DRB CASE ACTION LOG - BLUE SHEET

Project #: 1006543 Application #: 15DRB-~~70060~~70061
 Project Name: Albertsons at Coors
 Agent: Cartesian Surveys Inc. Phone #:

**CITY OF ALBUQUERQUE
PLANNING DEPARTMENT
February 4, 2015
DRB Comments**

RE: Lot 2, Albertsons at Coors SW

Sketch Plat
 for
acts 61A1B-1-A & 61A1A-1-A
Town of Atrisco Grant Unit 6
City of Albuquerque
Bernalillo County, New Mexico
 September 2013

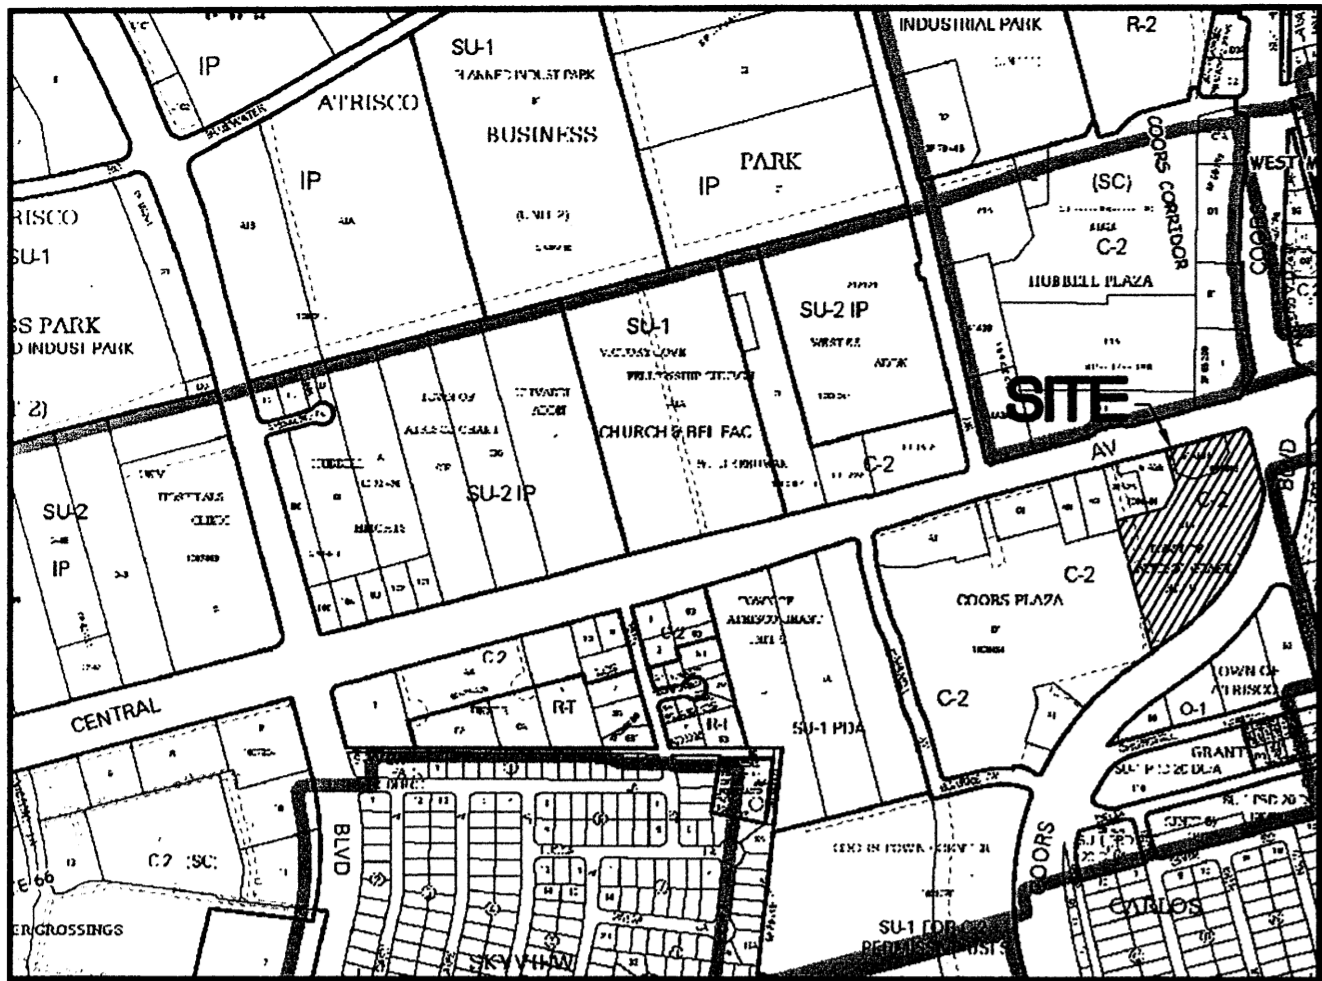
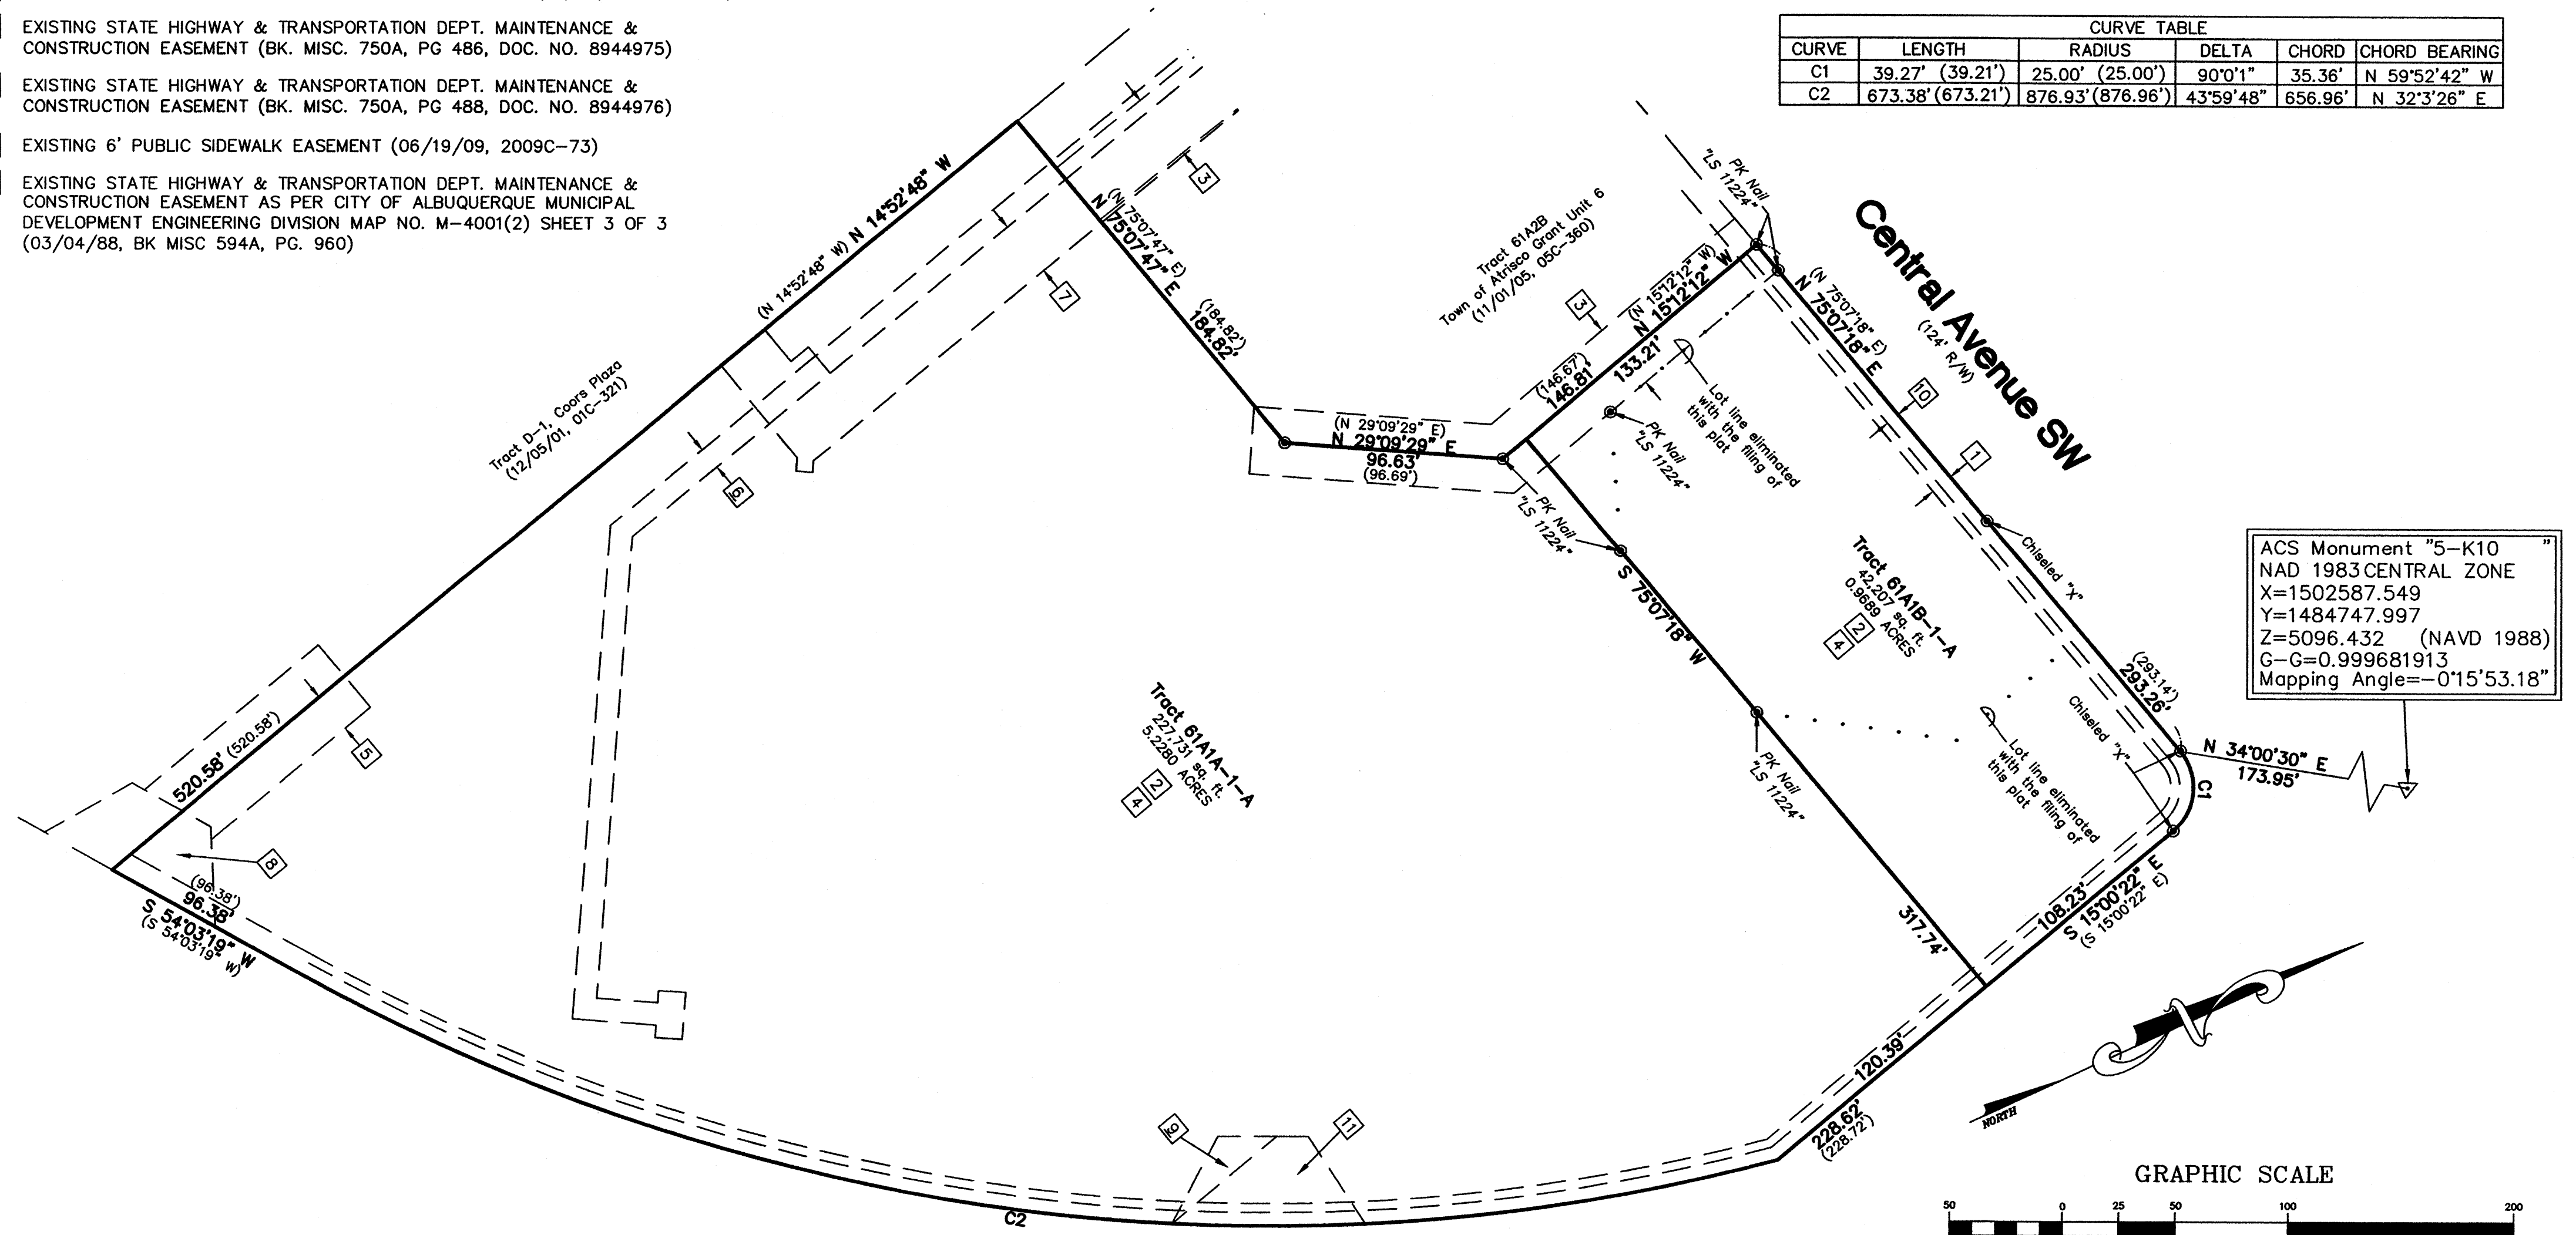
EPC approved Site Plan for Subdivision [Project No. 1006543] must be amended prior to platting.

It is not appropriate for lot lines to disregard site plan layouts (landscape islands, parking spaces, etc.);

**Plat for
 Lots 2-A & 2-B,
 Albertsons at Coors SW**
 comprised of
 Lot 2, Albertsons at Coors SW
 City of Albuquerque
 Bernalillo County, New Mexico
 January 2015

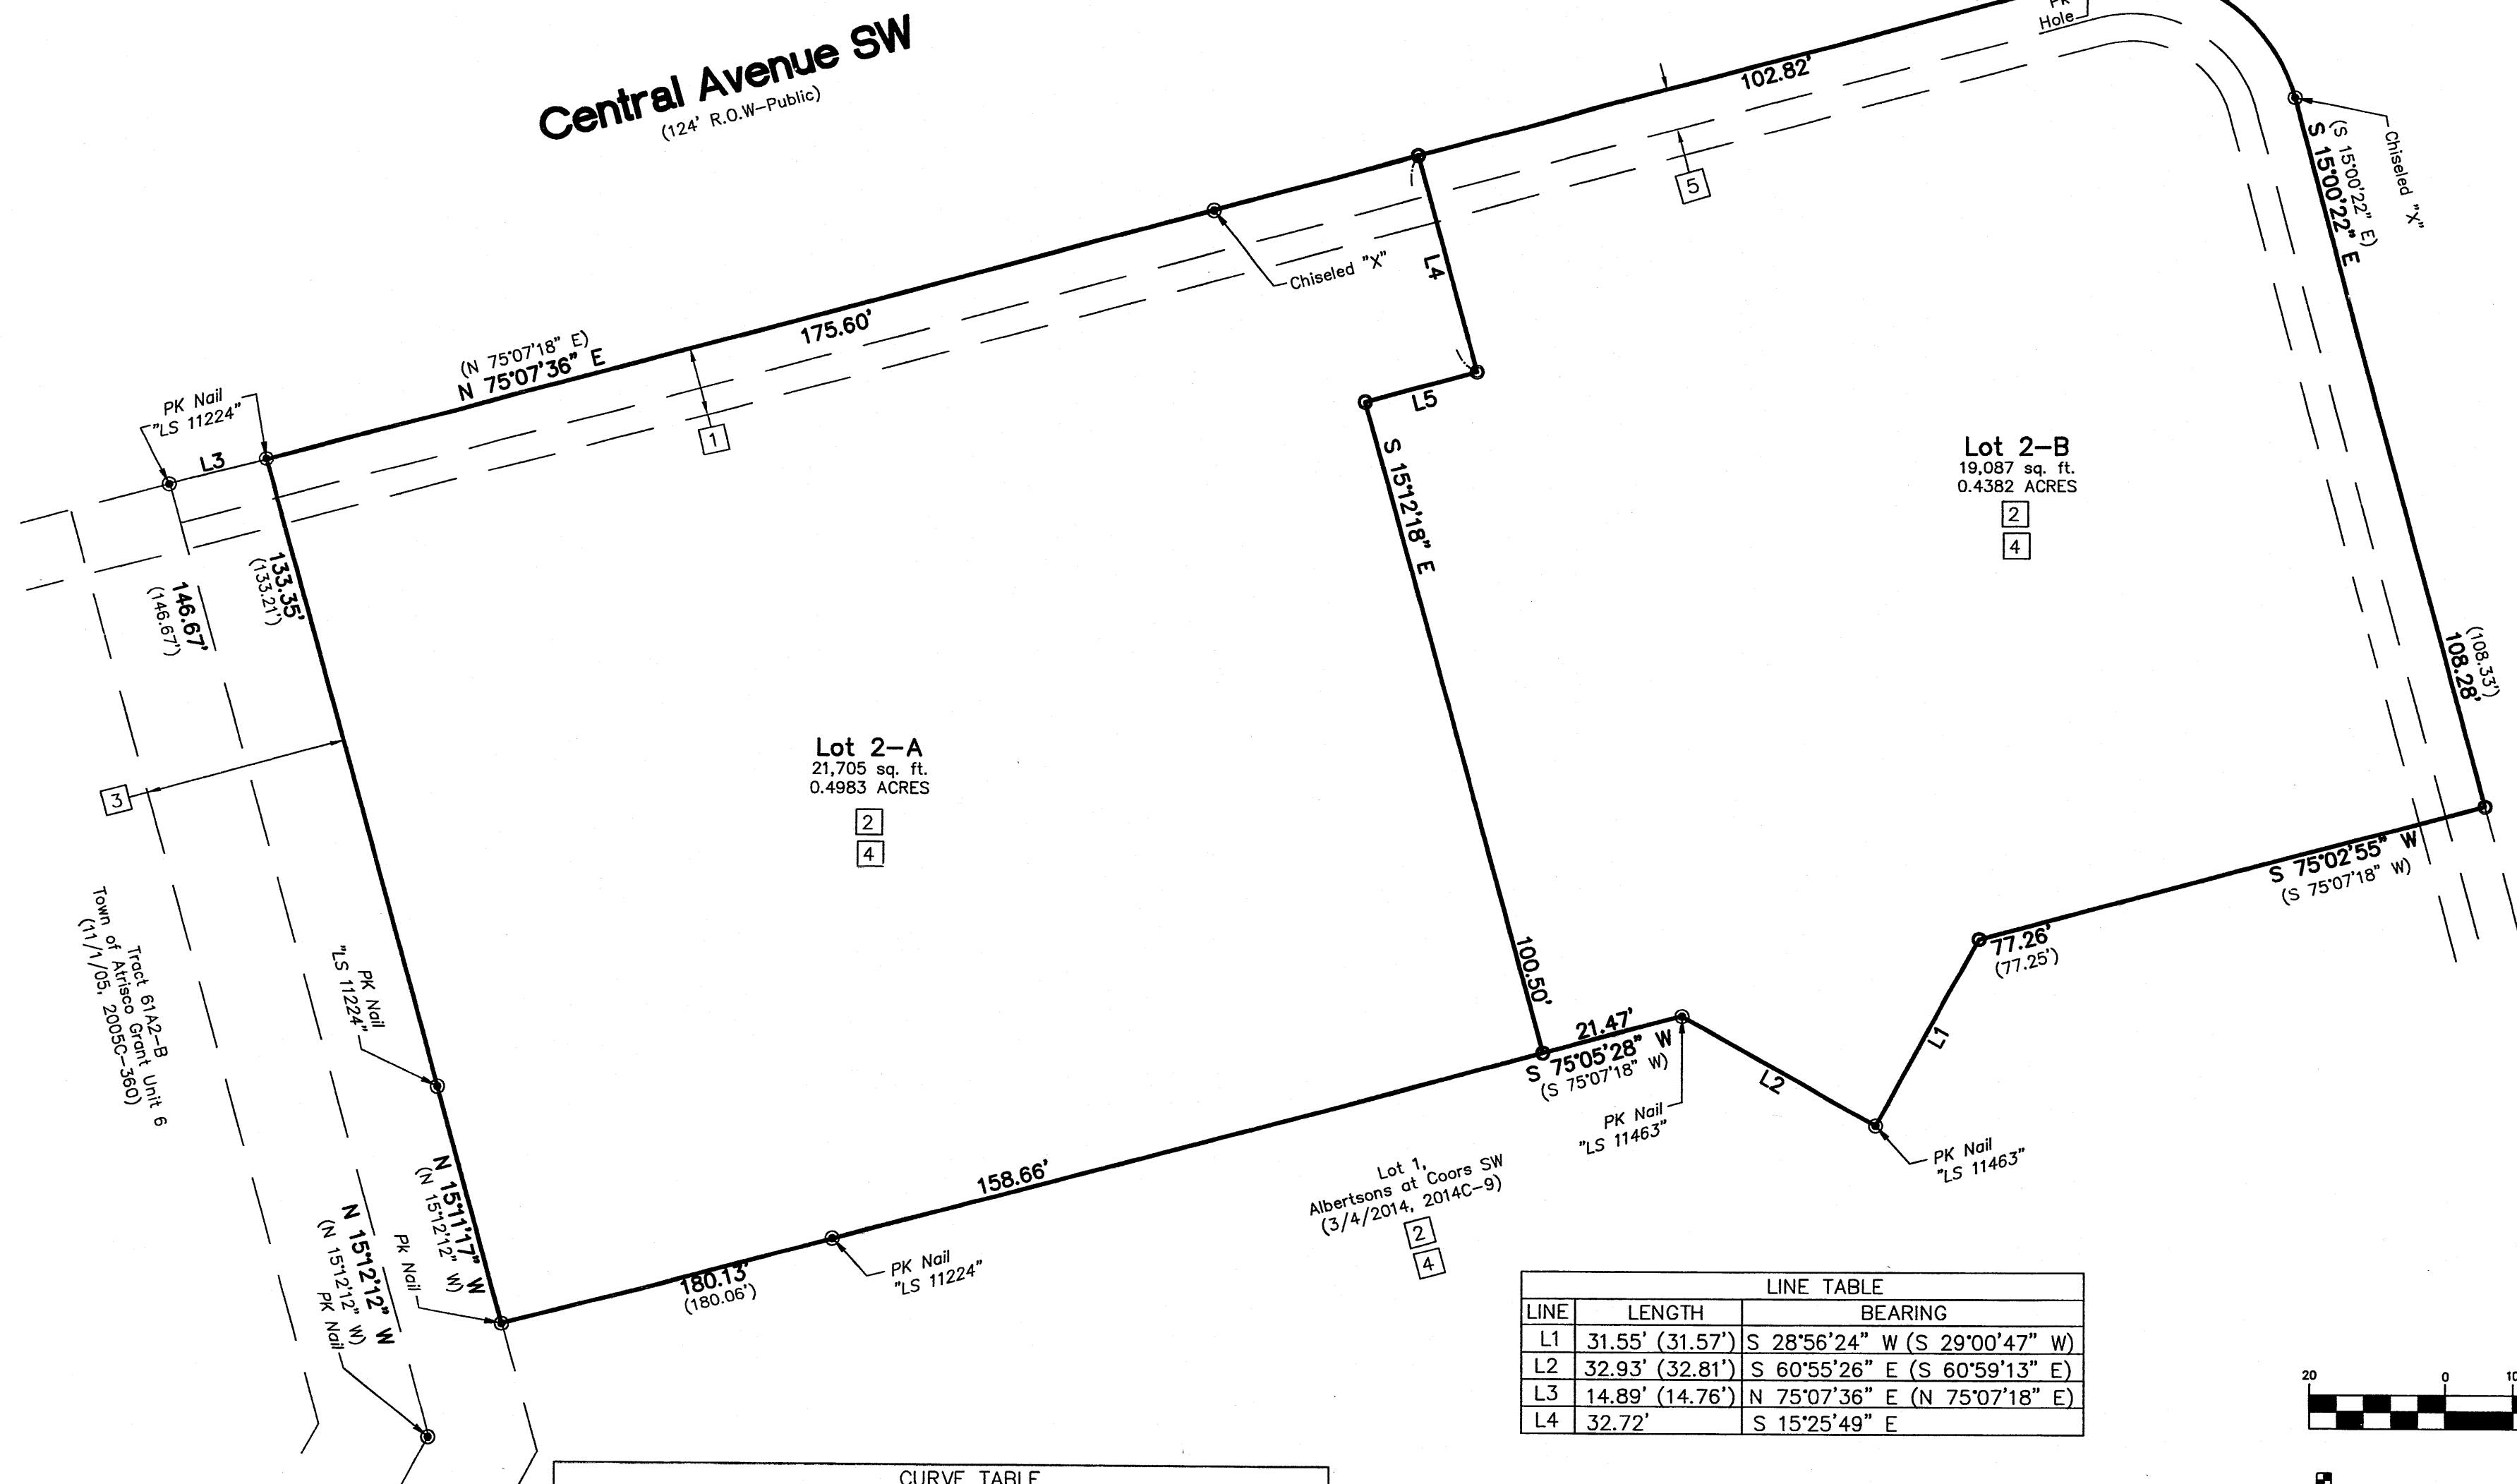
Please provide a complete copy of site plan (for building permit); per the Subdivision Ordinance, platting must conform with an approved site plan.

More information is needed for 'refuse area;' it appears an easement or lot line adjustment may be needed.

A complete line table needs to be provided.
